From: Jones, Janet <Janet.Jones@enwl.co.uk>
Sent: 09 July 2015 16:20
To: planning
Subject: Your Reference CONCS/3/2015/0515 (Contact Stephen Kilmartin) Our Reference PA2289

Land adjacent to 14 Church Raike, Chipping.

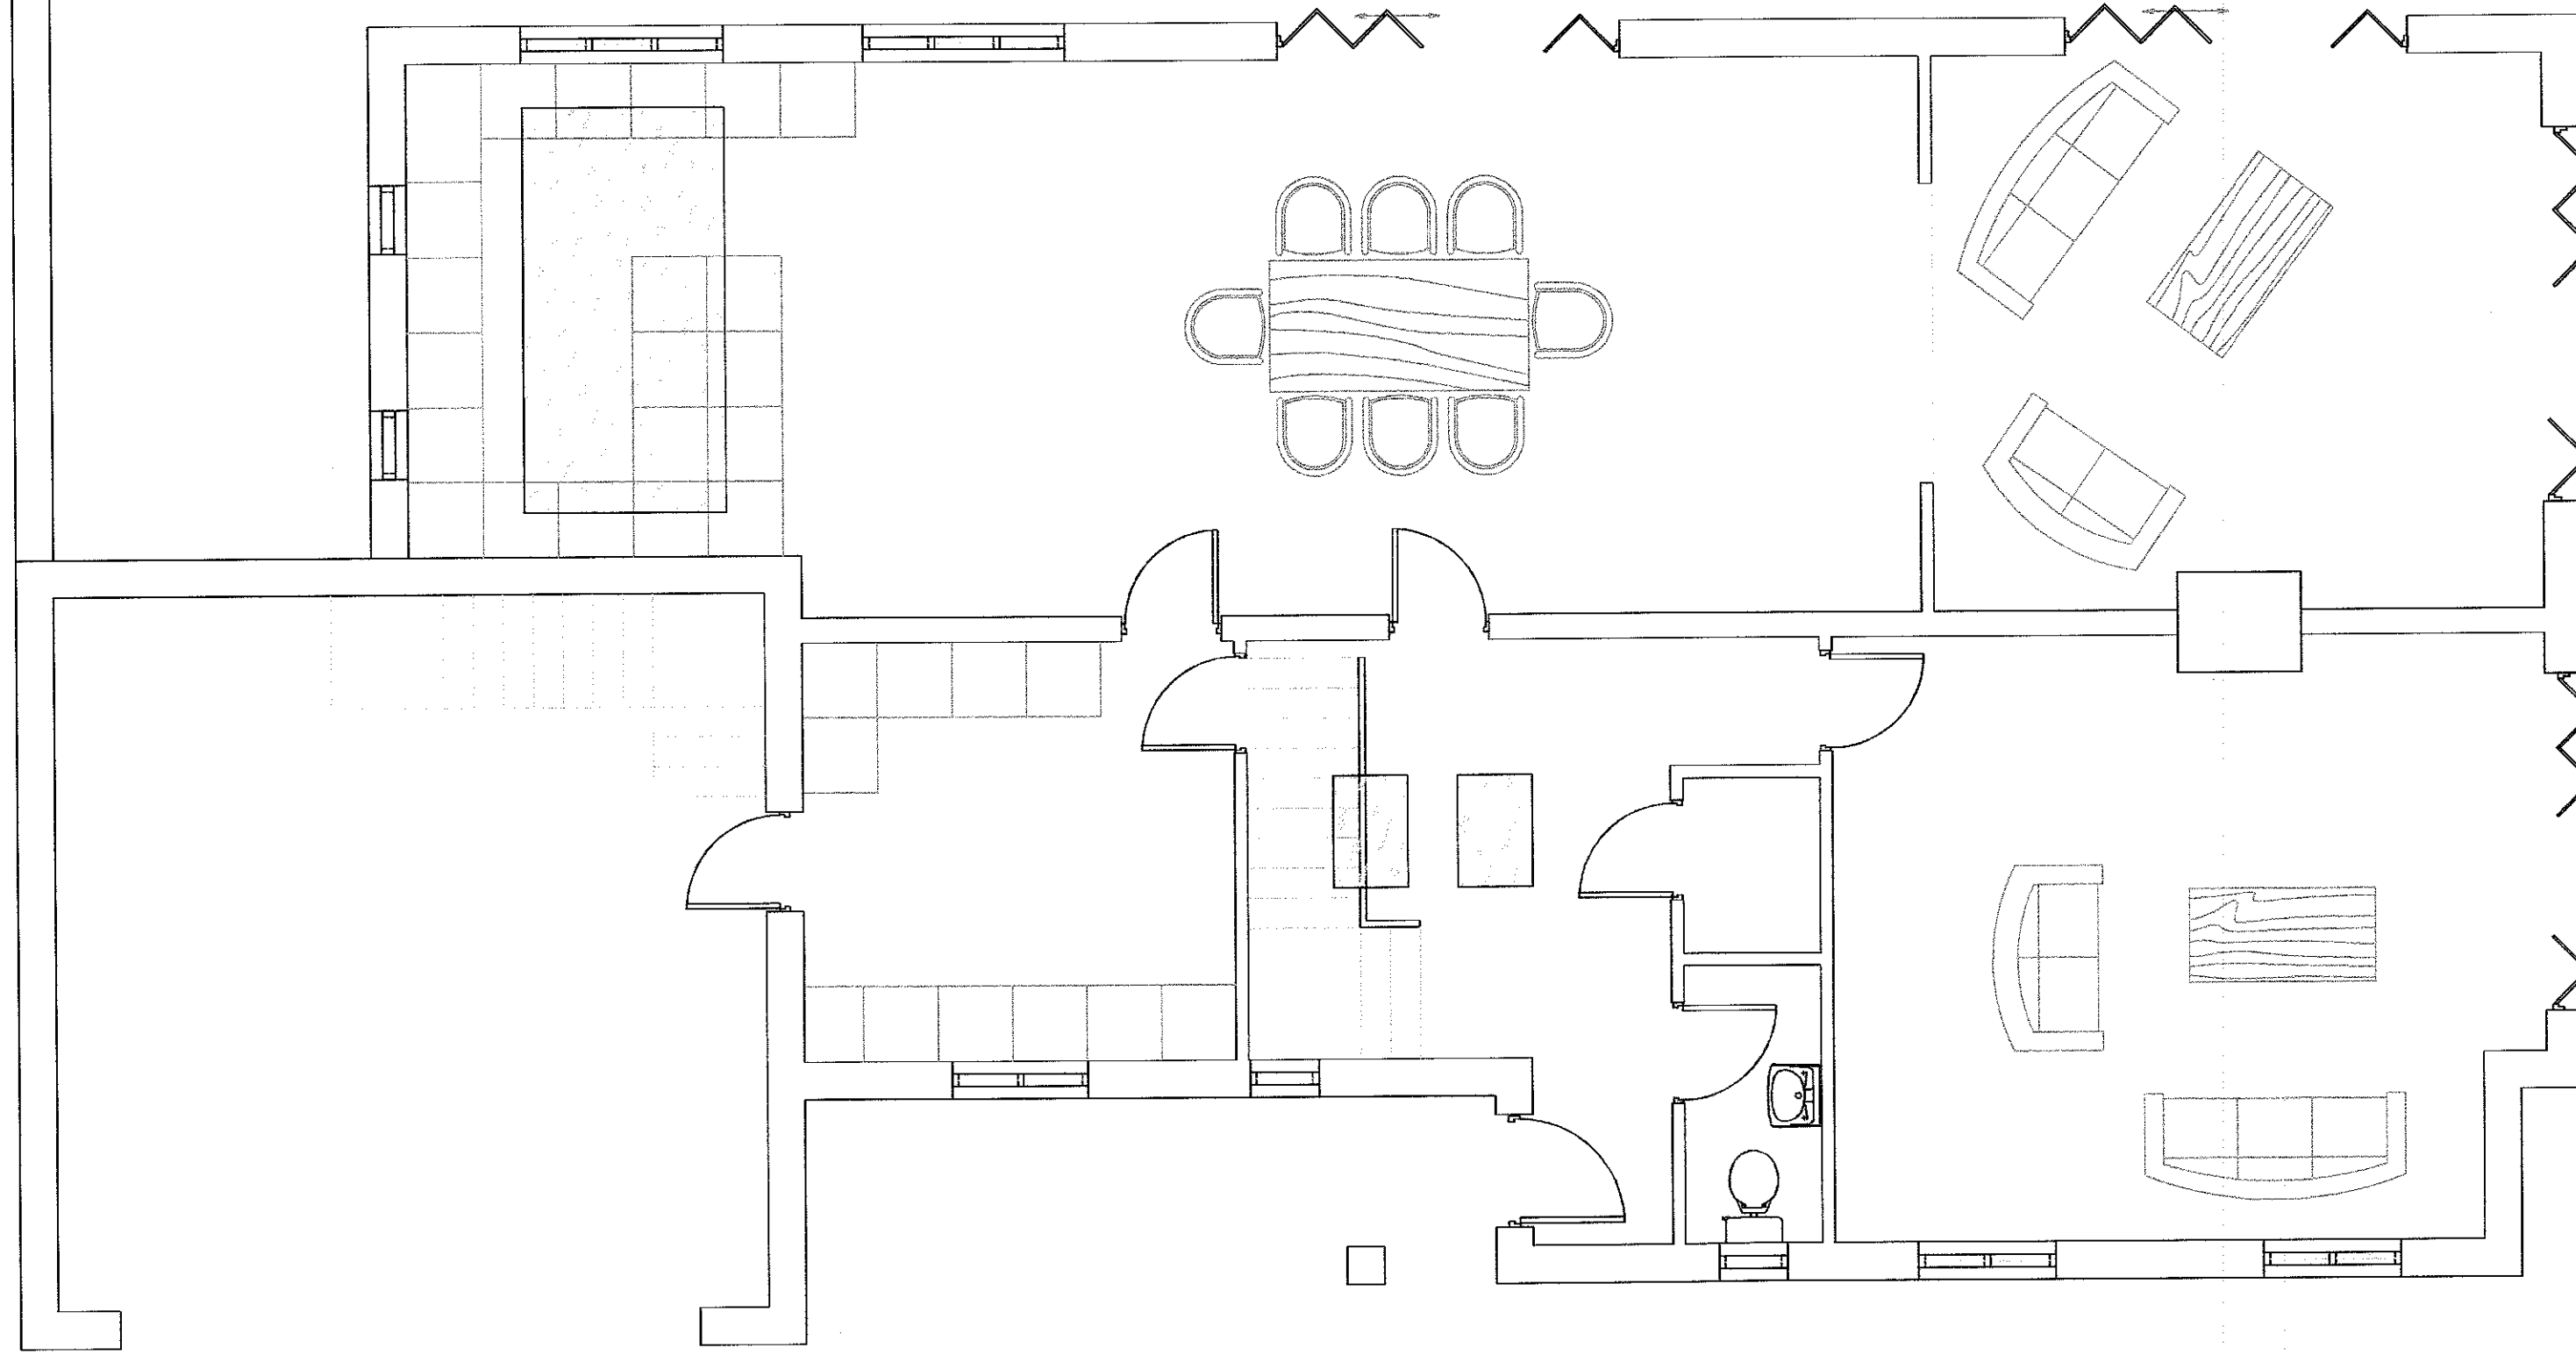
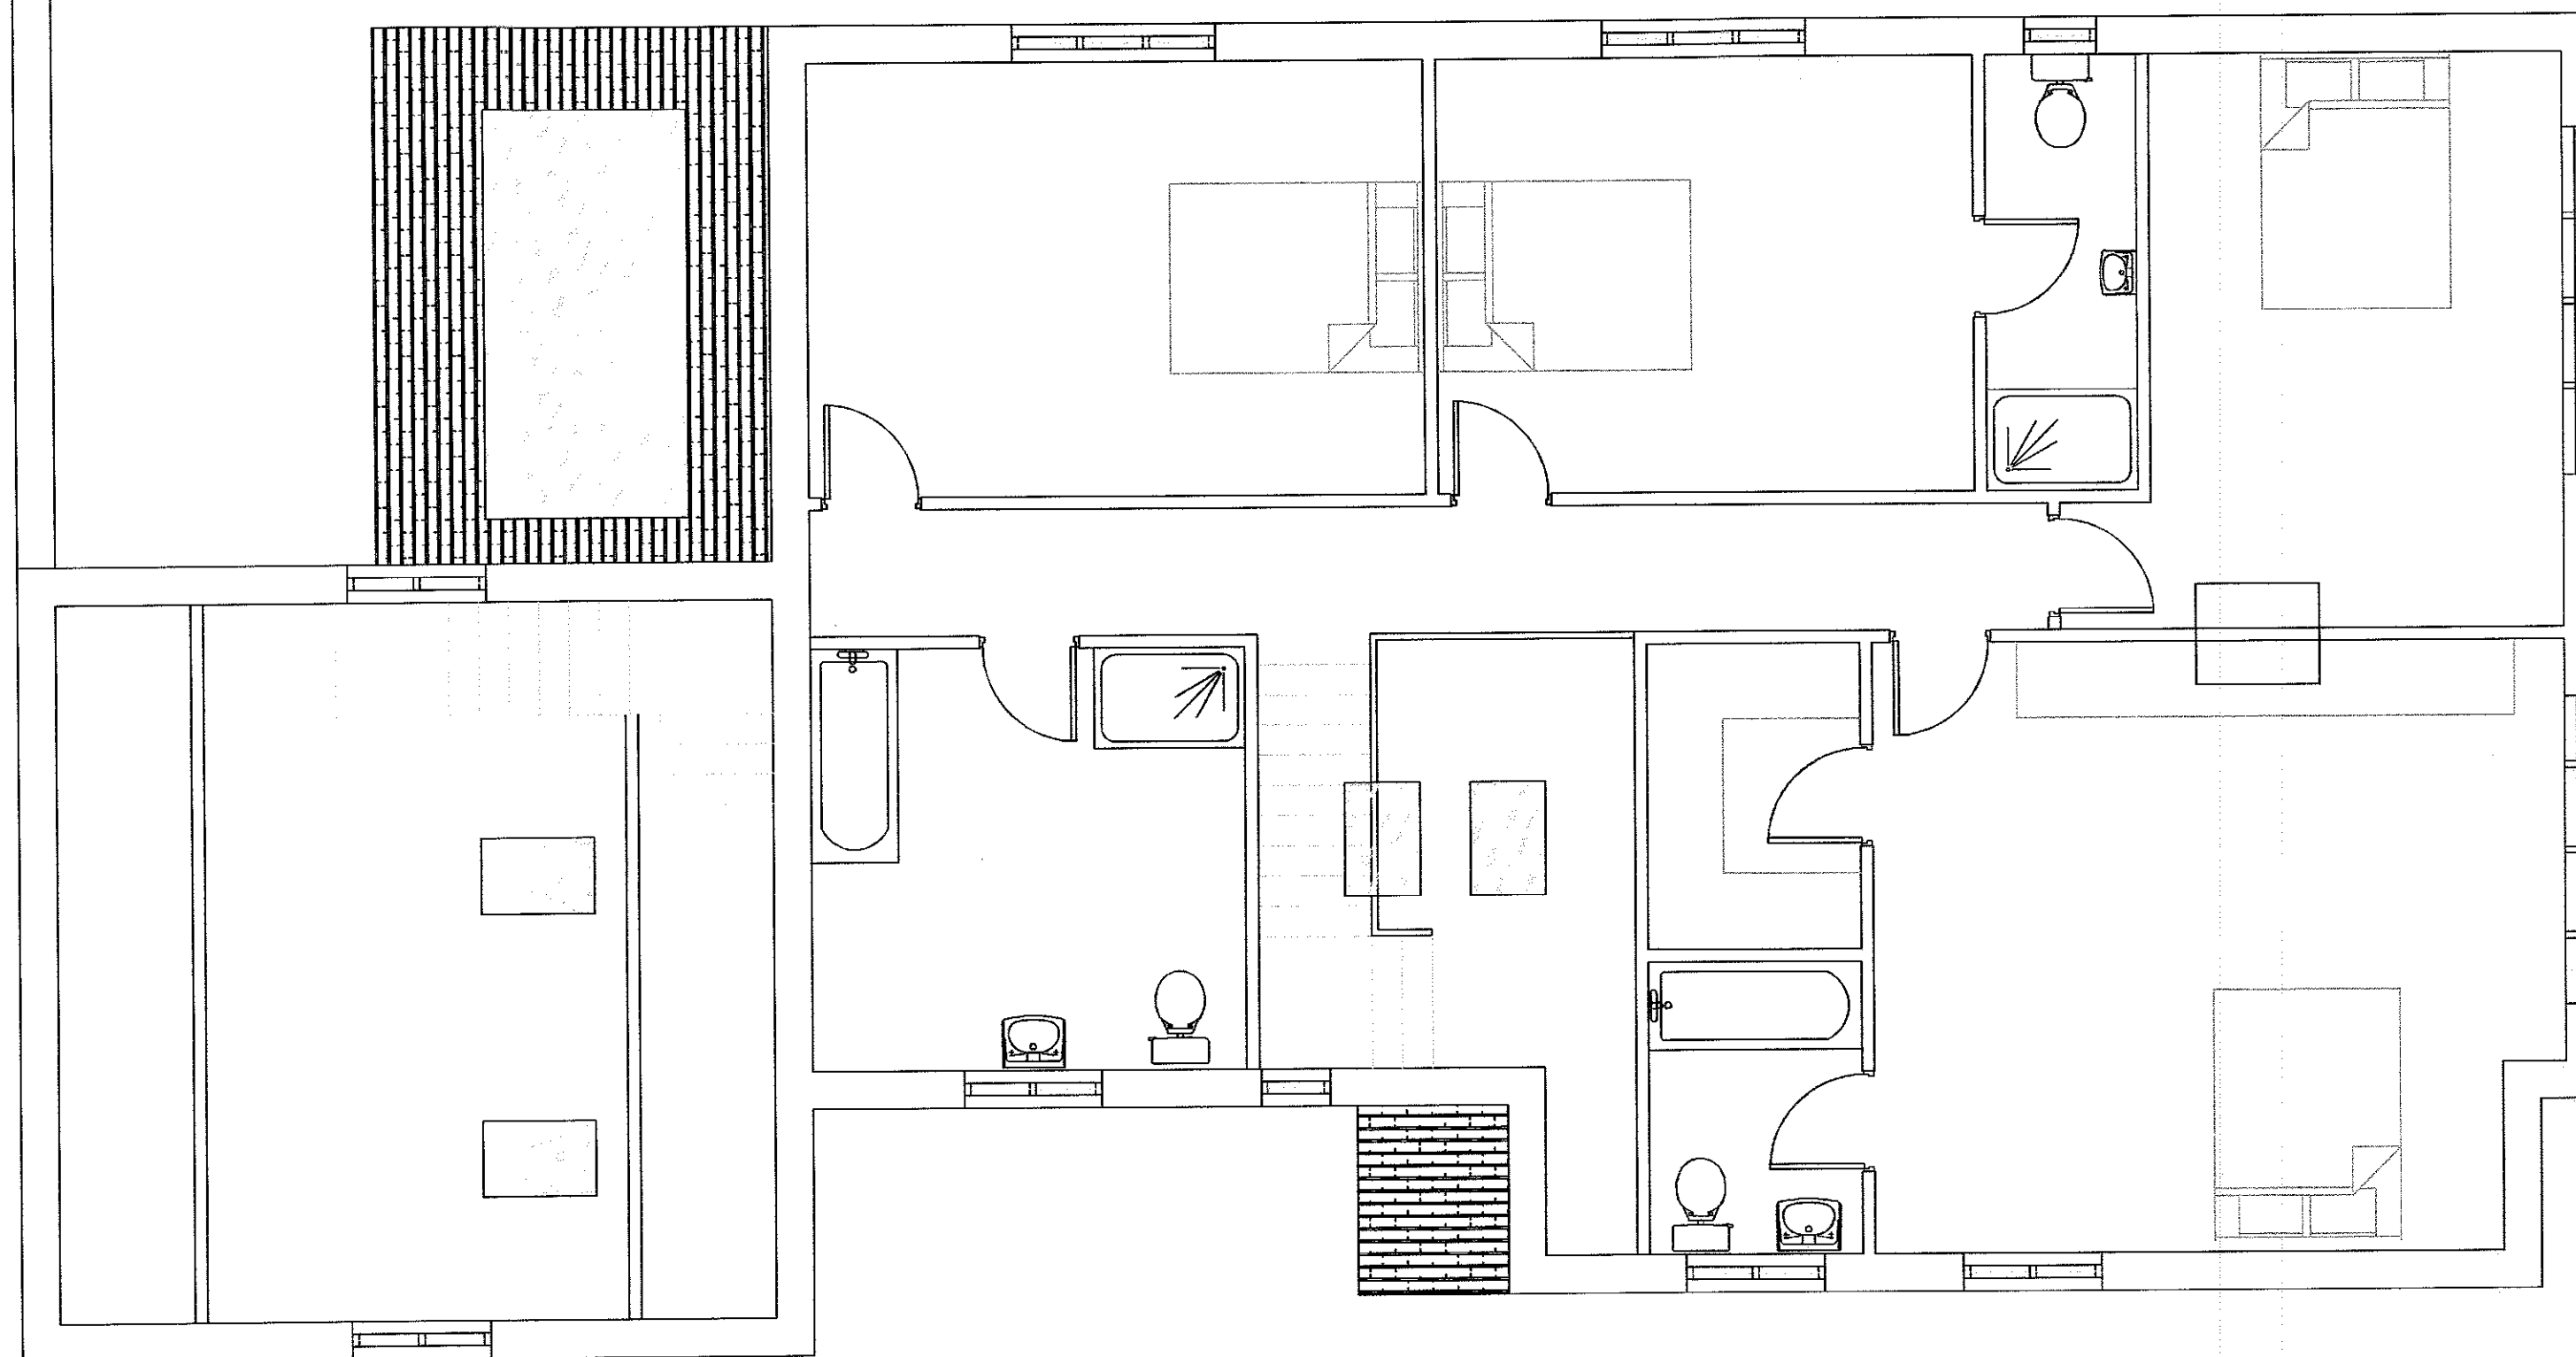
- To the western boundary of the development our records indicate a 3c .15 High Voltage cable crossing the site. The exact position of this cable should be confirmed before works on site commence. Based on the plans provided it appears to be within the outline of the garden and not the footprint of the proposed building. Care must be taken should any excavation be required to landscape the garden to ensure that this cable is not affected.
